**RE: Application by Rampion Extension Development Limited for an Order Granting Development Consent for the Rampion 2 Offshore Windfarm Project**

### **Horsham District Council Deadline 4 Submission**

## **EN010117: Application by Rampion Extension Limited for the Rampion 2 Offshore Wind Farm**

HDC Response to the Applicant's additional information/submissions received Deadline 3.

System Identifier: 42285-WSPE-EX-ON-FG-OL-7754				Version: 0
Company: WSP	Drawn By: N.Bunn	Chk/Apvd R.Ryloc	Drawn Date: 25/04/24	Status: FINAL

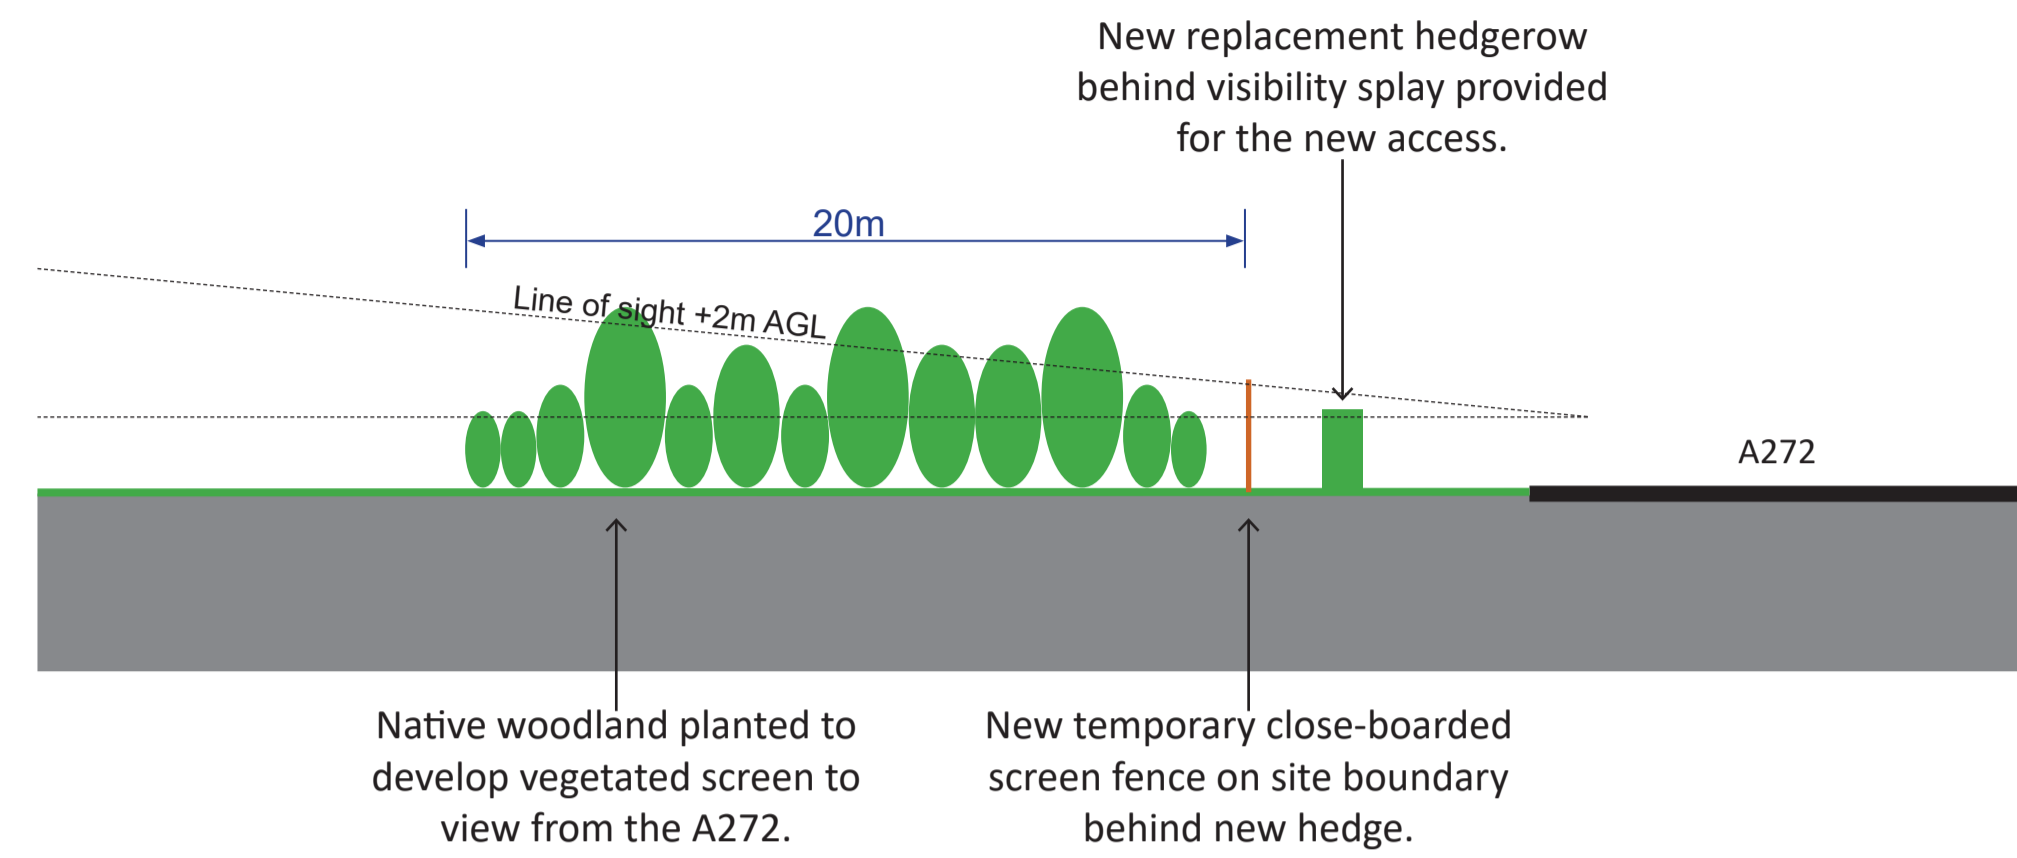
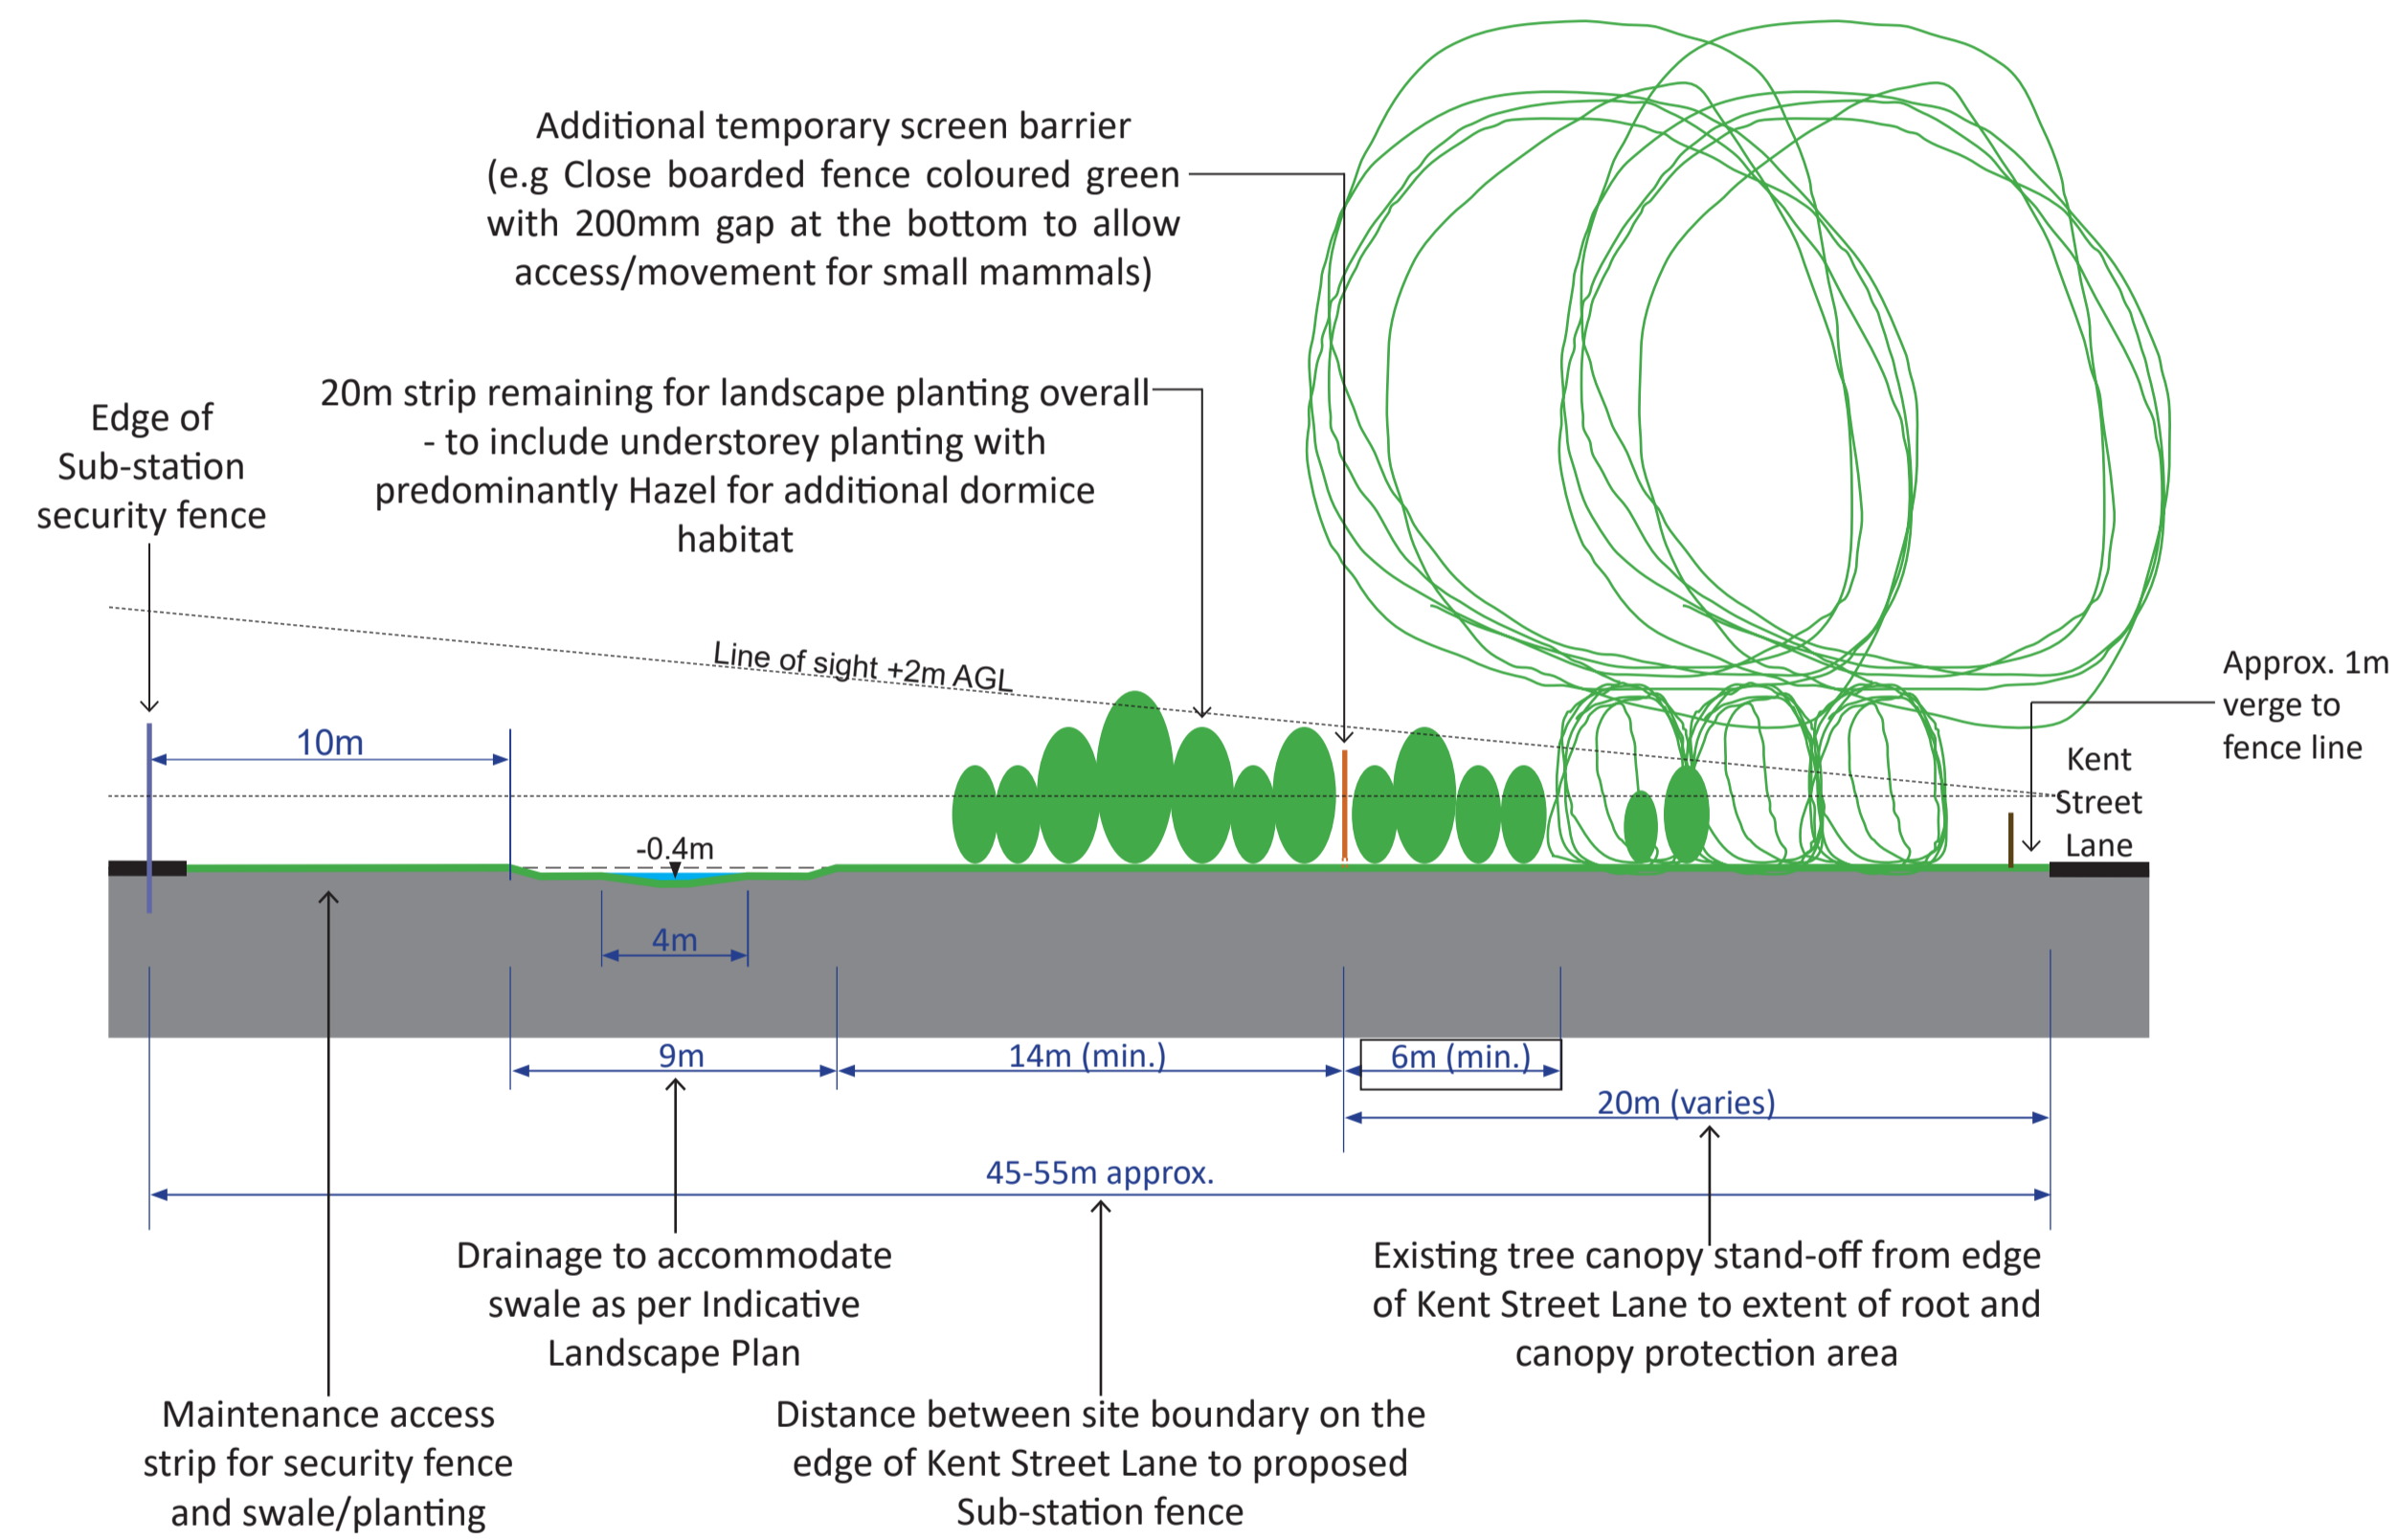
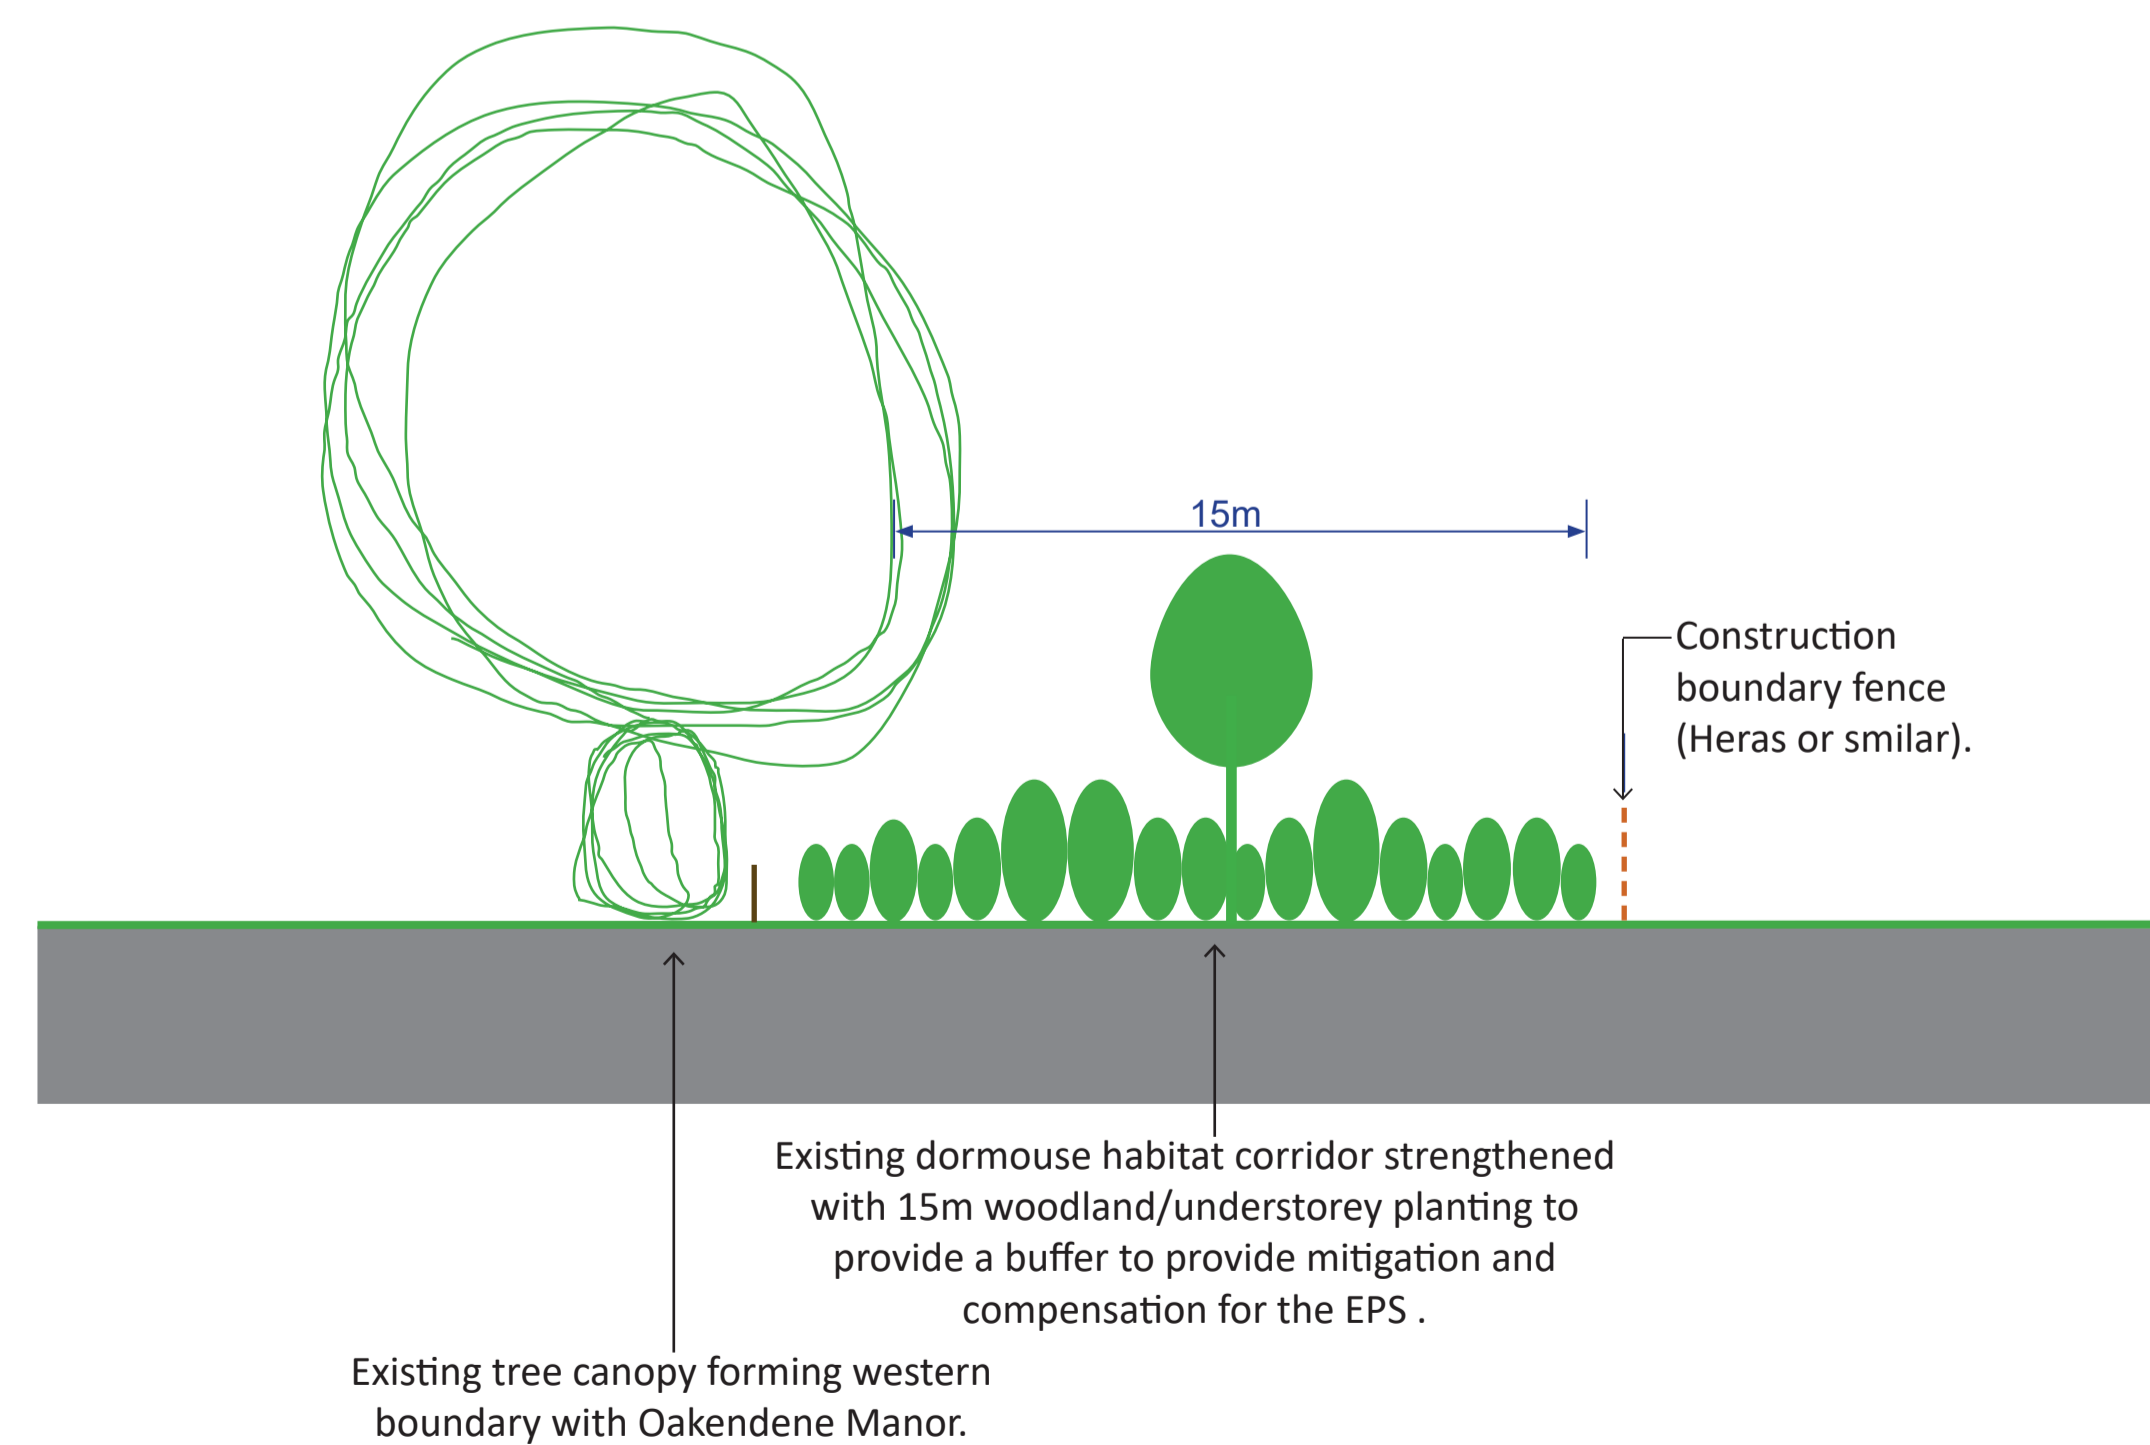
|   | <i>HDC raised concerns with the mitigation on-site at the Oakendene substation site for hazel dormouse. Gaps in the hedgerows bordering the site, specifically in the south-west of the site, meant connectivity to the wider landscape would be severed. Given that wet woodland is suboptimal</i> | <i>The Applicant responds with 'The Outline Landscape and Ecology Plan [APP-232] (secured via Requirement 12 within the Draft Development Consent Order [PEPD-009] which has been updated at Deadline 2) will be updated for Deadline 3. The indicative landscape plan within it will be revisited in light</i> | It is positive to see the amendments to the Oakendene Substation Indicative Landscape Plan with reference to the infill planting at pre-commencement stage, to close gaps in existing hedgerow providing better connectivity for hazel dormouse. Supplementary planting has also been proposed within and adjacent to existing hedgerows to provide a buffer for mitigation and compensation for the EPS.   |

|  | <i>habitat for hazel dormouse, HDC requested that the connectivity of the scrub and hedgerow along the edge of the west of the site were restored with further scrub planting, to ensure mitigation is robust.</i>  | <i>of the comments raised by Horsham District Council.'</i>  |  |
|  | <i>10.14 Within the Oakendene substation, mitigation measures comprise of enhancement planting along boundaries, replacement planting, 'advance planting' and an architectural strategy. Advanced planting is given a wide range of 4 years to be delivered, anytime during the construction period and before the operational stage stages. Types of materiality to be used within the substation building and principles of the architectural strategy are not defined within the current suit of commitments, including the Design and Access Statement. HDC expects to see the content of this tightened at this stage in the DCO process to provide more certainty at detailed design stage.</i> | <i>Ref 10.14 (...)<br/><br/>The LEMP is secured through Requirements 12 and 13 of the Draft Development Consent Order [PEPD-009] which has been updated at Deadline 2. Requirement 8 (2) of the Draft Development Consent Order [PEPD-009] requires detailed design for the substation to accord with the principles established in the DAS [AS-003]. The Applicant is considering possible amends to the DAS [AS-003] as a result of matters raised at the Issue Specific Hearing 1 in February 2024.</i> | HDC welcomes the clarification at LV5 that the existing perimeter vegetation along the southern boundary will be maintained by providing a trenchless crossing and additional commitment and clarifications to advance planting. |
